Job ID: 2012-09-4996-ALTCOMM

**Benjamin Wallace - Allagash Brewery - 50 Industrial Way - permit 2012-09-4996-ALTCOMM**

Hi Michael,  
I have the Allagash permit and a few questions I need clarified.

NEW ADDITION FOR ALLAGASH BREWING COMPANY  
50 INDUSTRIAL WAY ; PORTLAND ; MAINE 04103

FIRST FLOOR FACILITY CODE COMPLIANCE PLAN
SCALE: 1/16" = 1'-0"

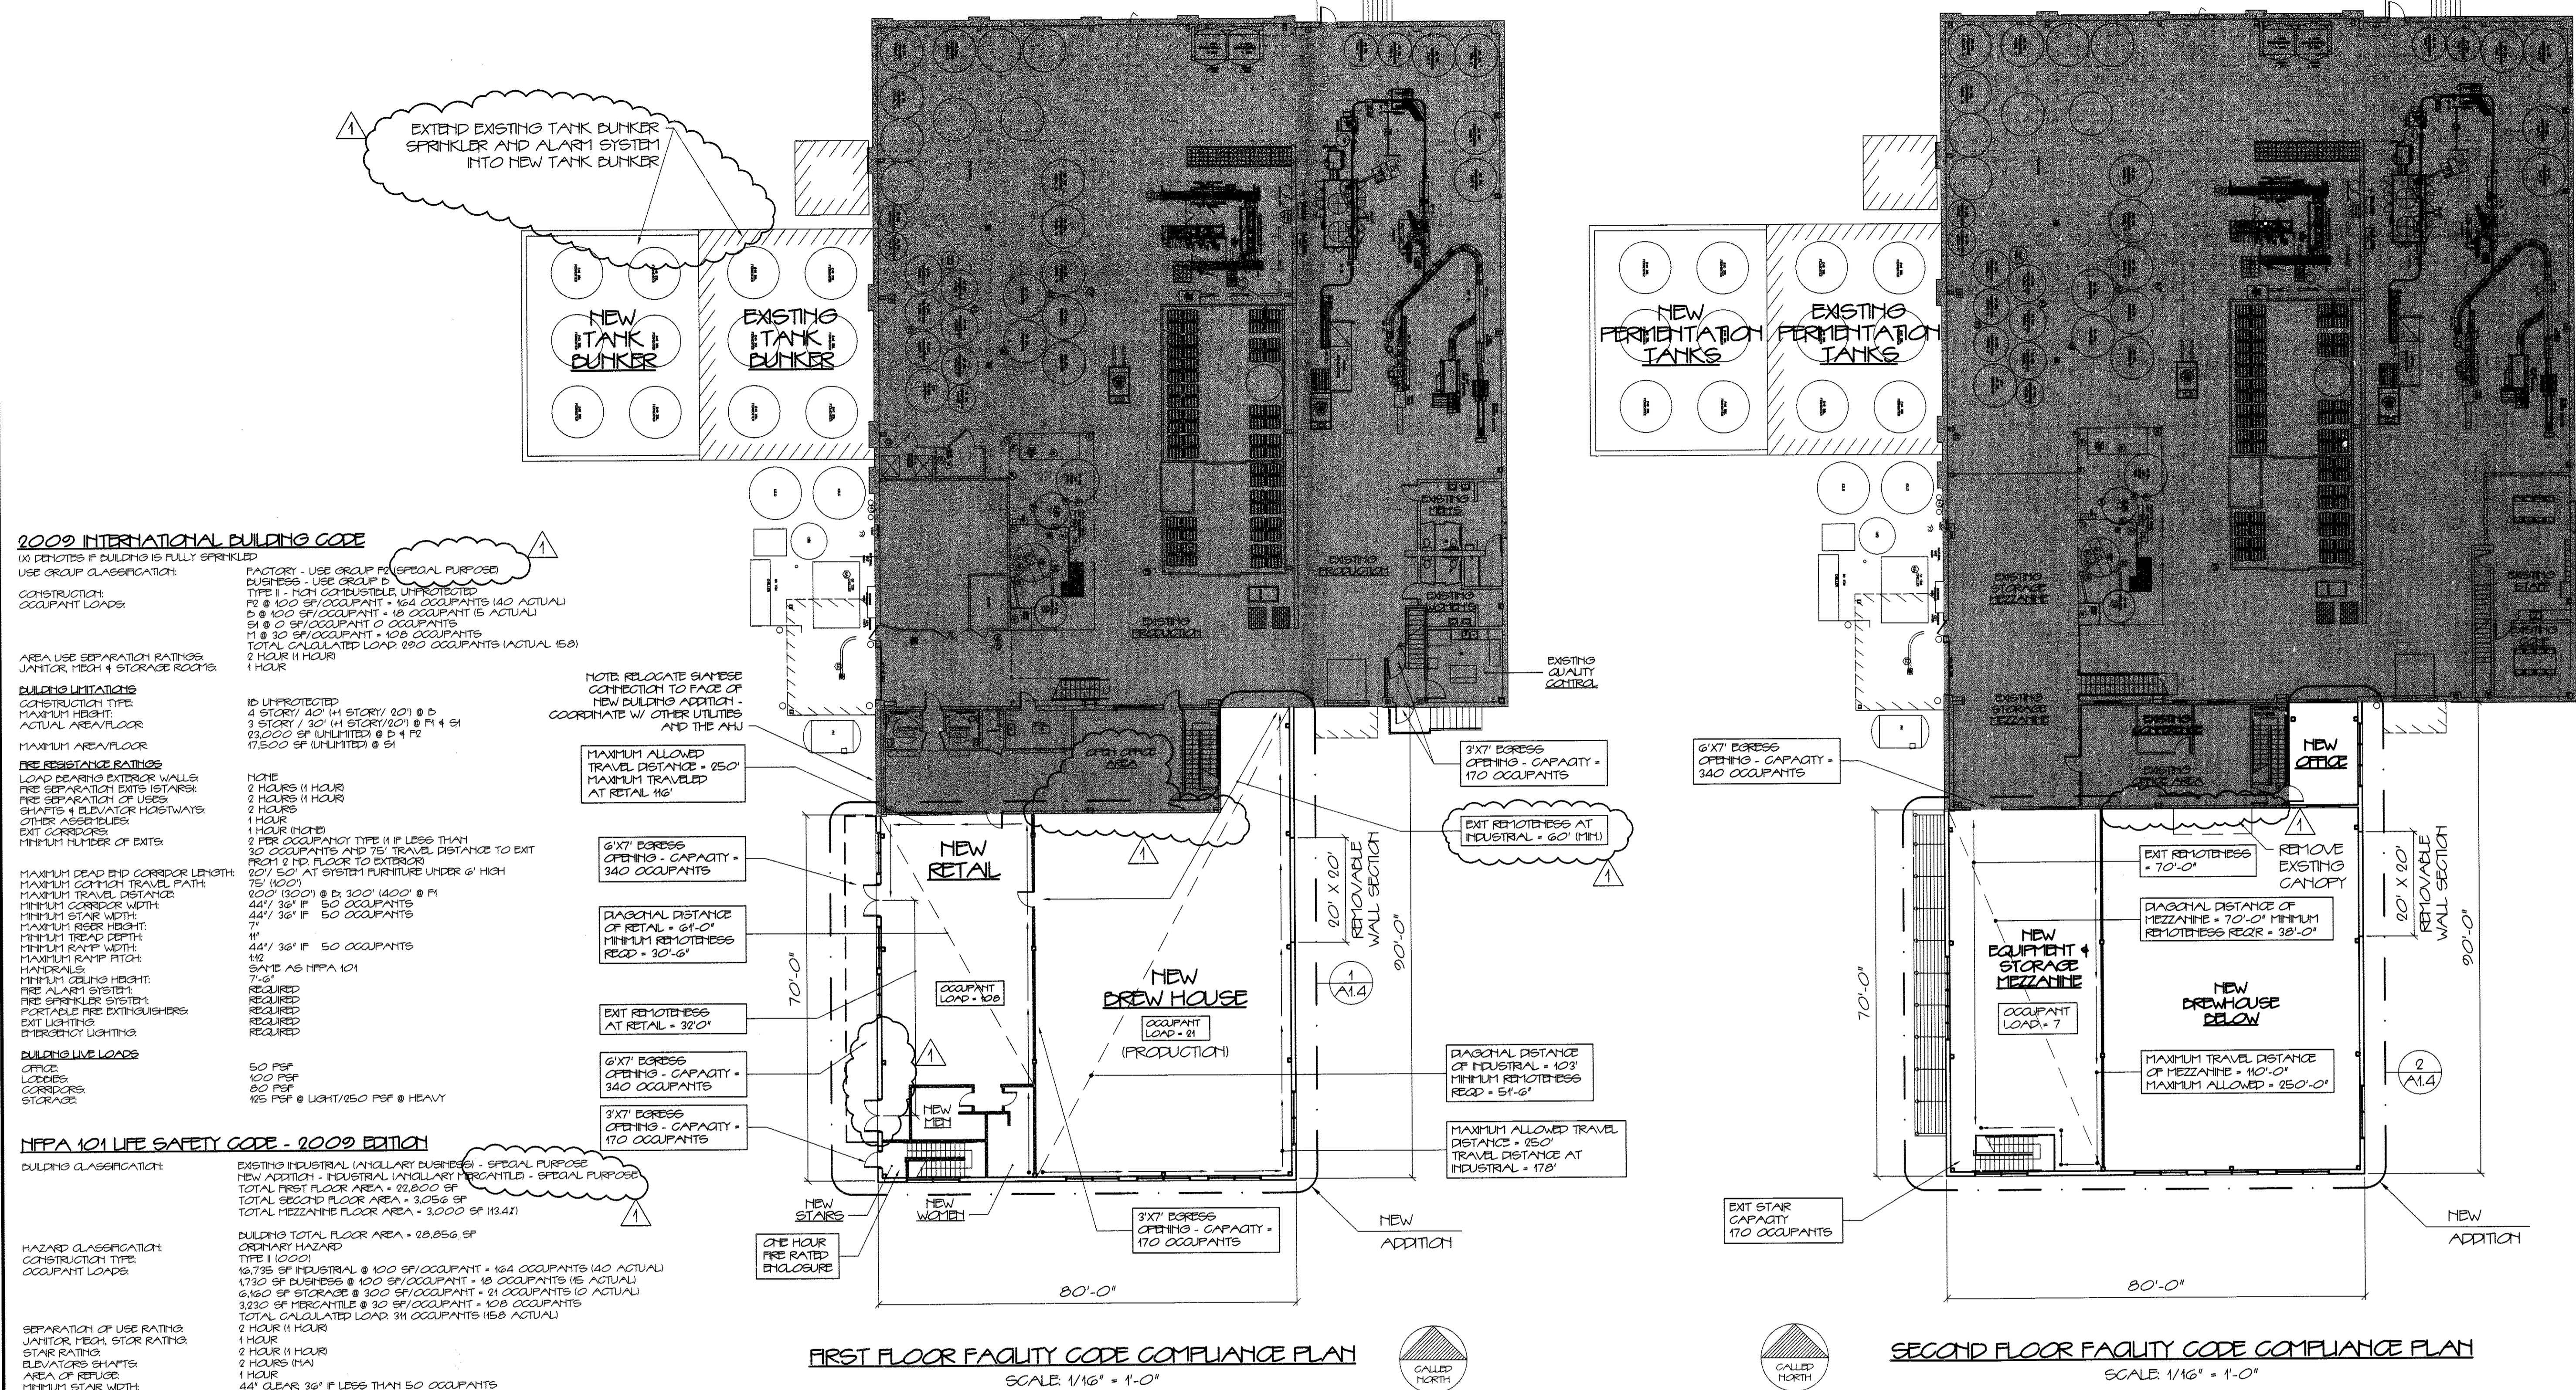
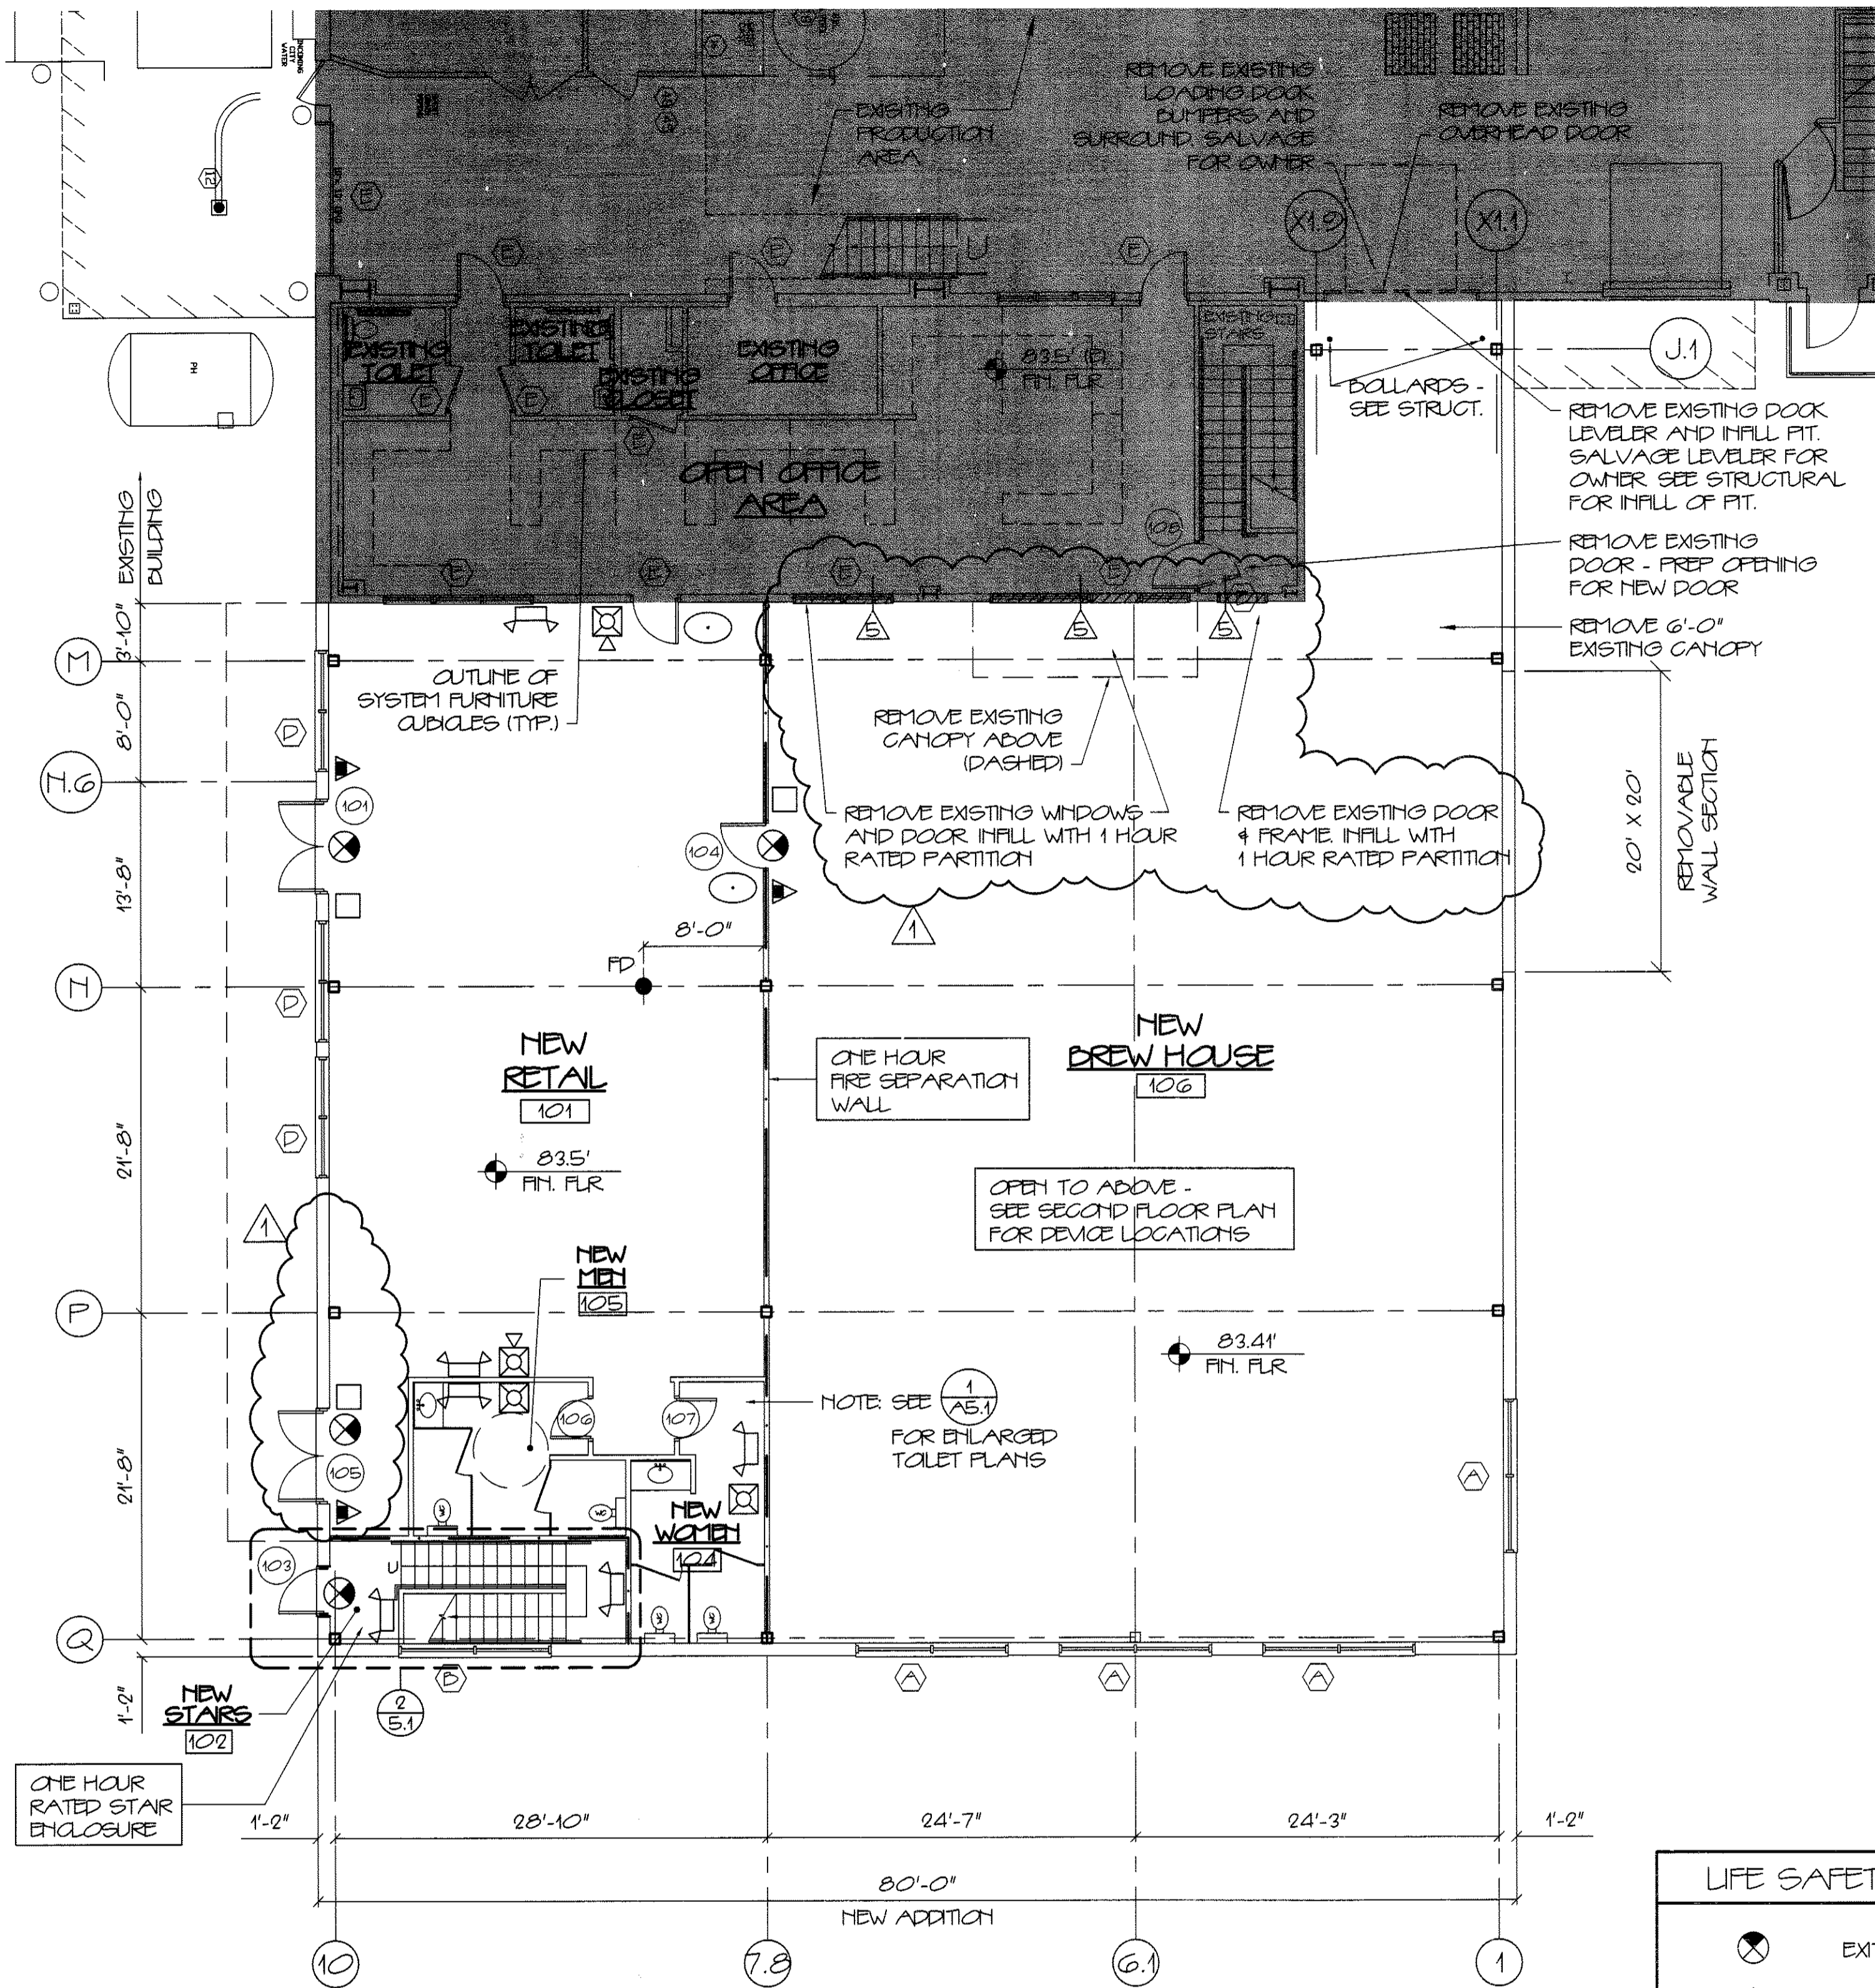
1. What is the occupancy sub-classification (NFPA 101:40.1.4.1)? I'm not sure this meets the intent of Special-Purpose Industrial so I think it's general purpose industrial.

2. The "mezzanine" does not appear to meet the area limitations of 101:8.6.9.2. Please explain if it is a mezzanine in accordance with the *Life Safety Code* or a story and how that affects your exits and separation of stories.

3. The plans show 1-hour wall separation between the new mercantile area and the Brew House but not from the "mezzanine" above or the production area in the existing building where the mercantile is currently located. The North wall of the new mercantile space was an existing exterior wall with windows and a door and is assumed to have no fire resistance rating. Please explain both.

4. The existing exit stair from the second floor office space currently discharges directly outside. The South and East exit stair walls are assumed to have no fire resistance rating. Please explain this and also how the single exit from the new office space is allowed to discharge through the level of exit discharge (Brew House) which might be considered a hazardous area. Please also consider 101:40.2.5.1 when explaining.

7. The new stair from the mezzanine is not enclosed at the top as required by 101:7.2.2.5. Please explain.
8. Please explain if the fermentation tank bunkers are required to be protected by sprinklers under the scope of NFPA 13, *Standard for the Installation of Sprinkler Systems*, 2007 edition. It looks like they are covered by the building's roof and may have walls around them?
